# A417 Missing Link DCO

Joint Councils Deadline 5 submission

9 March 2022

Document title: Joint Councils Deadline 5 submission

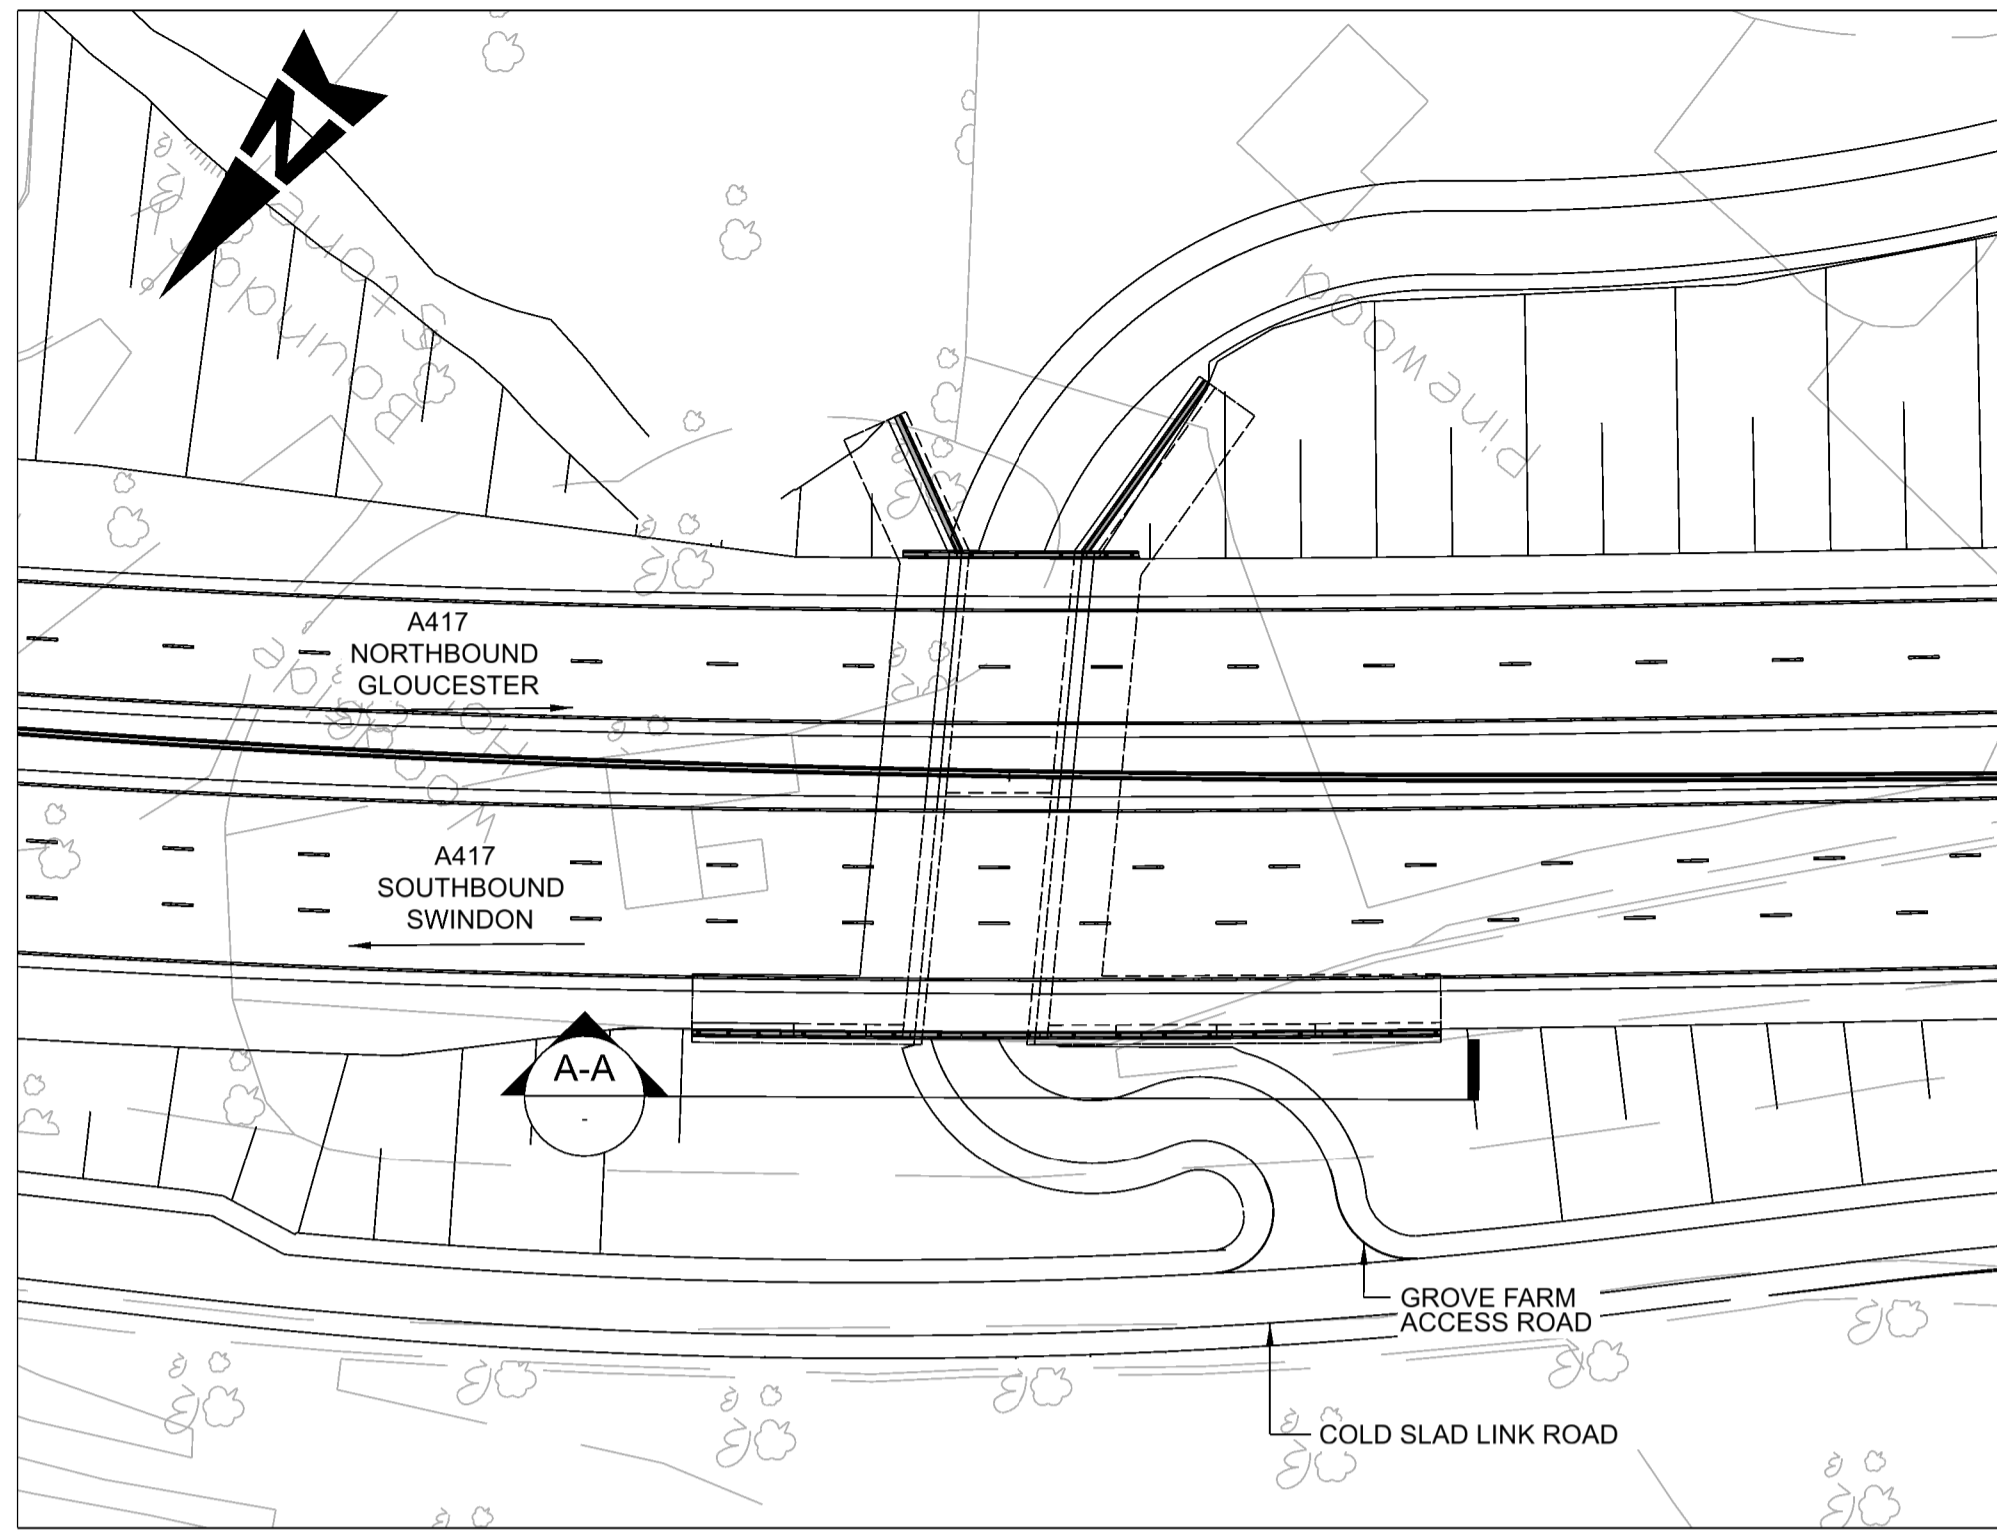
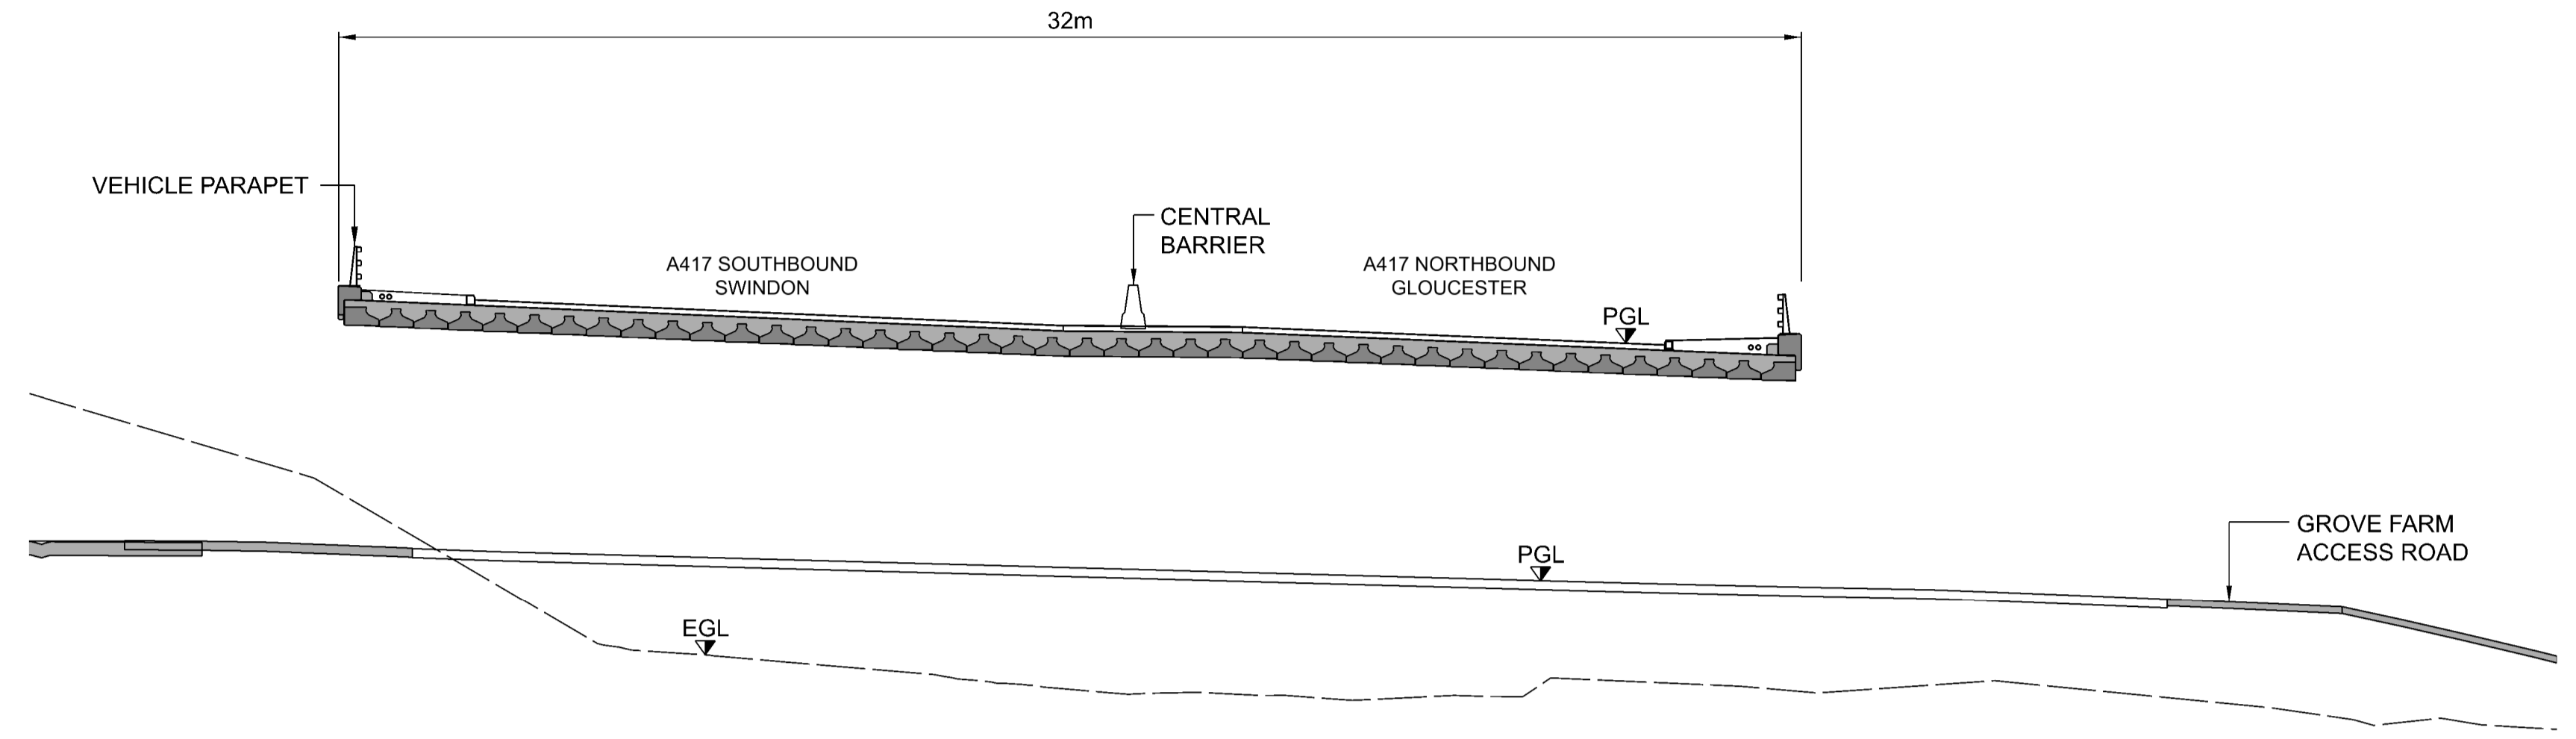
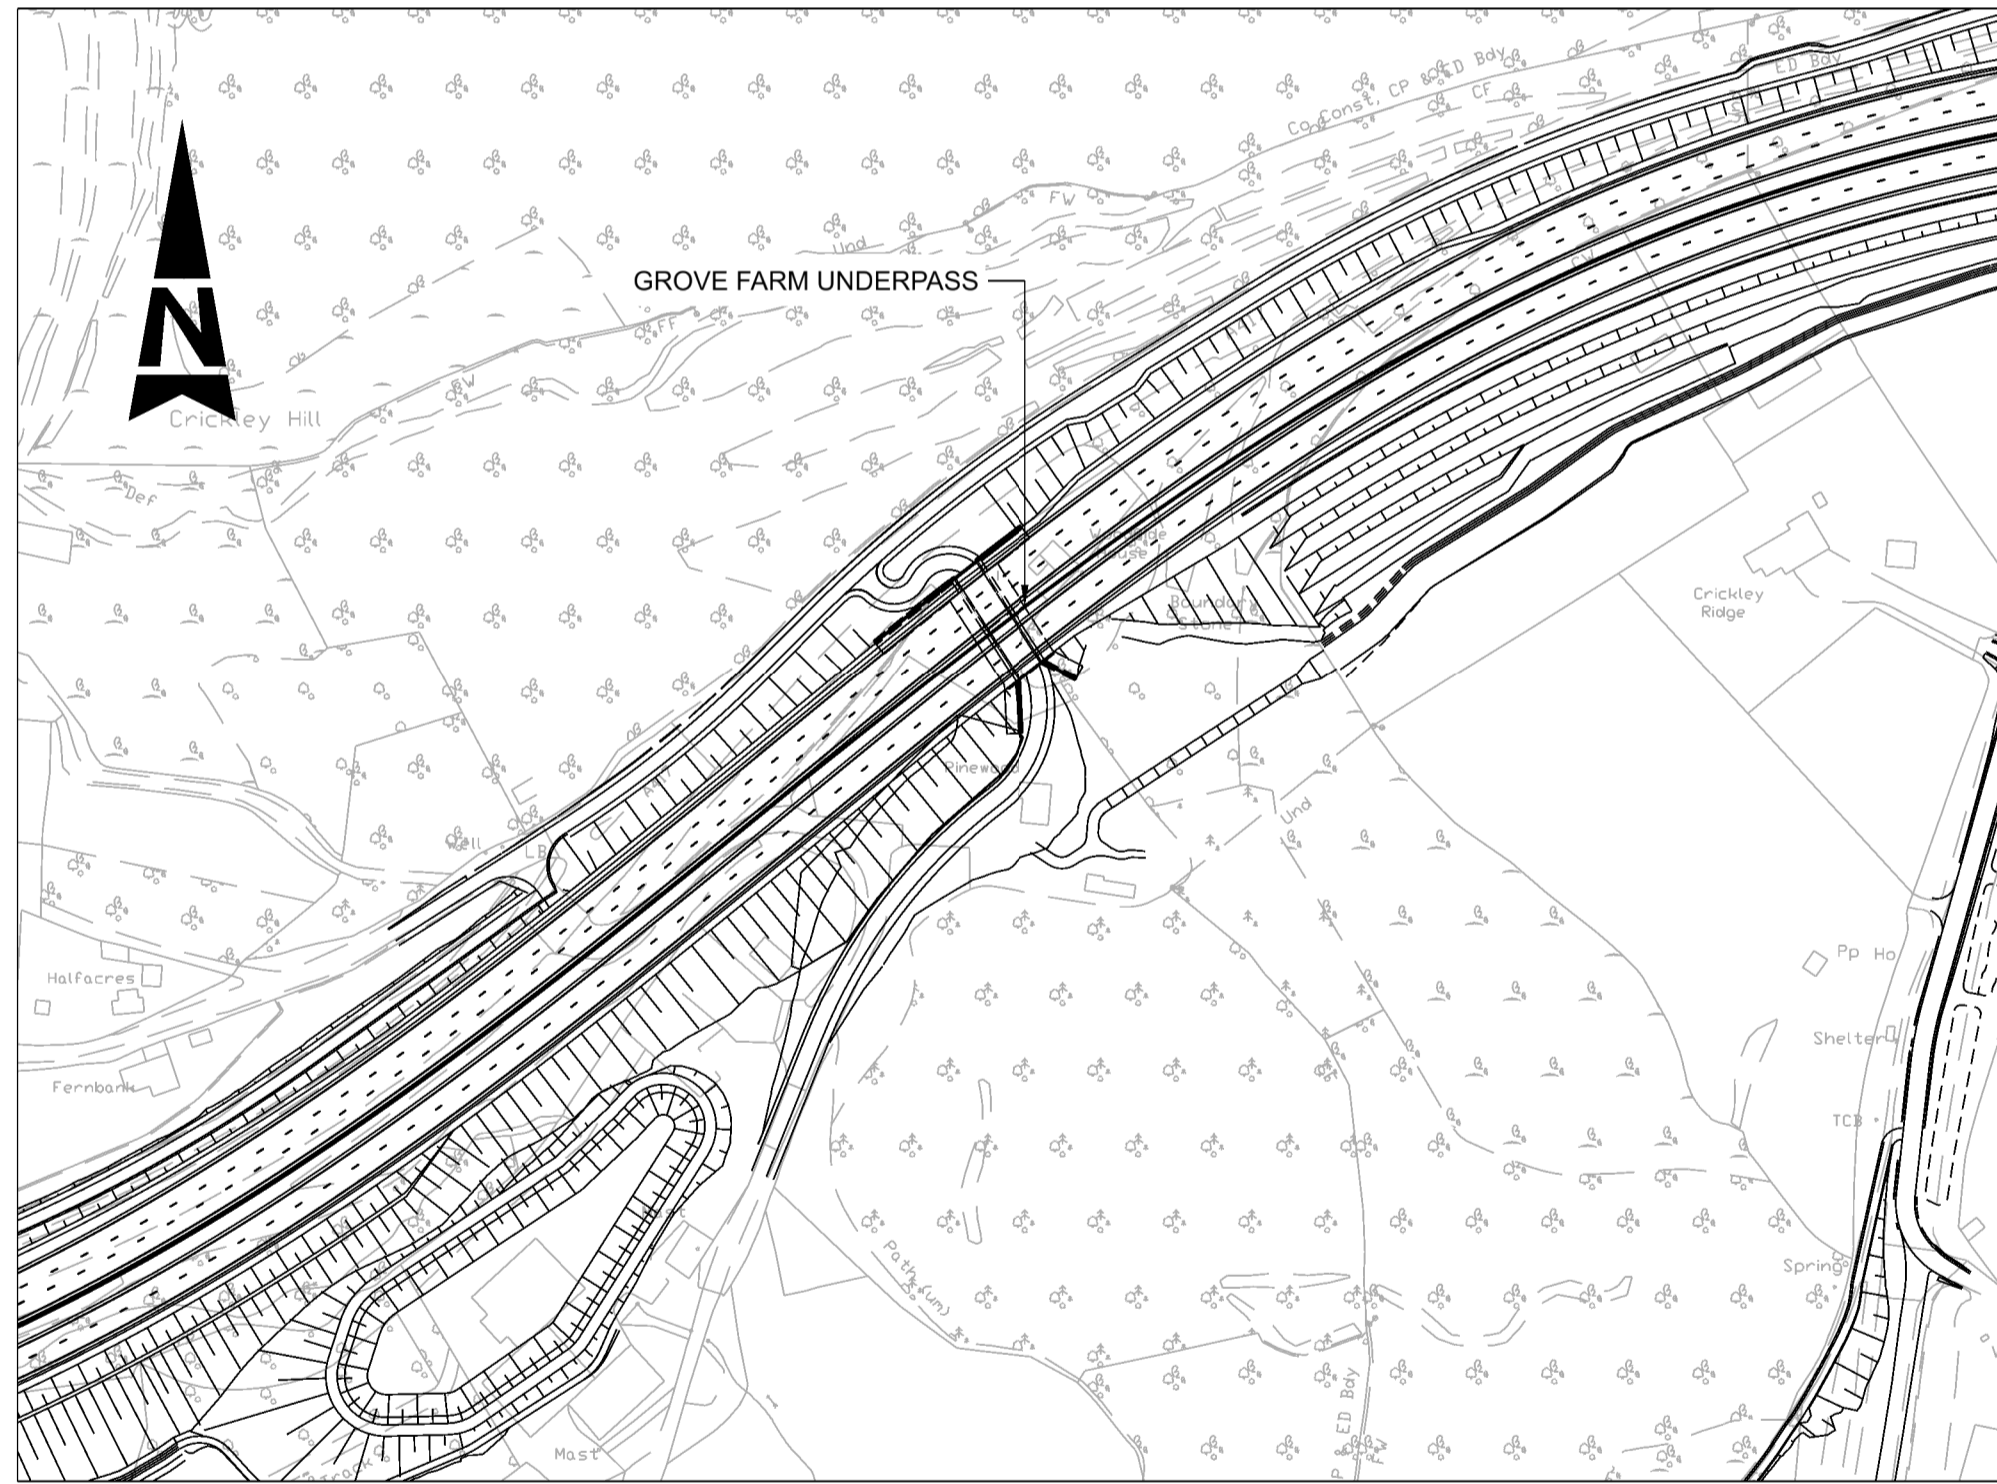
- There should be clear evidence that the structures will make a positive contribution to sense of place
  - There should clear commitments to ensure the Gloucestershire Way Bridge will be engineered to successfully sustain calcareous grassland and hedgerow habitats and that there is a clear long-term management plan for this structure

- There should be clear evidence that the suite of bridges – Gloucestershire Way bridge, Stockwell bridge and Cowley bridge will provide both human and wildlife connectivity. We are still concerned that these structures will not provide the necessary landscape connectivity nor be engineered to sustain habitats (whether hedgerows and trees on Stockwell and Cowley, or full habitat creation on Gloucestershire Way bridge).
